Planning Application Reference: BR/37/22/PL

Proposal: Change of use from residential care home (Use C2) to a 10 bed House in Multiple Occupation (Sui Generis). This application is in CIL Zone 4 and is Zero Rated as other development.

Location: Cordell House Rest Home 120 Victoria Drive Bognor Regis PO21 2EJ

Drawing
Site Plan

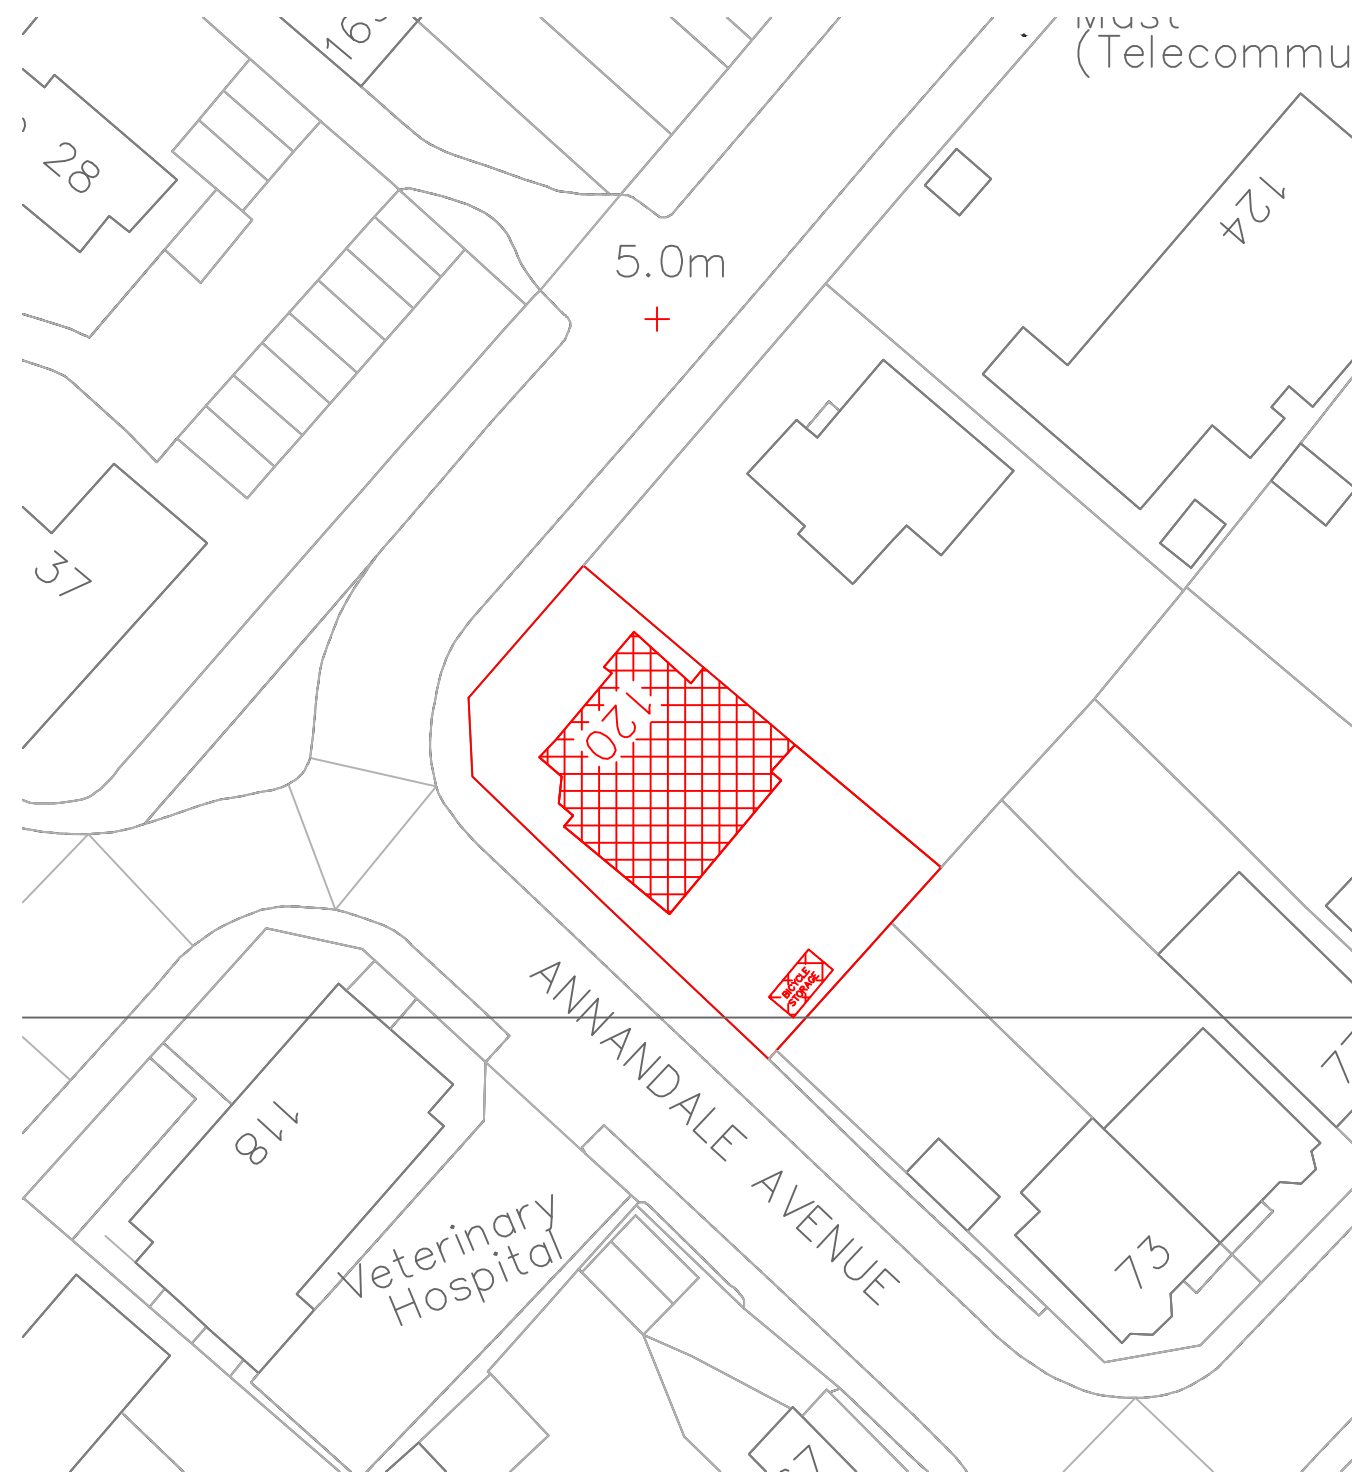
The application does not appear to include consideration for the provision of waste receptacles for general waste or recyclables. I request the applicant submit full details for waste disposal provision.

I would recommend the proposal should also consider provision of cycle stores to promote sustainable transport.
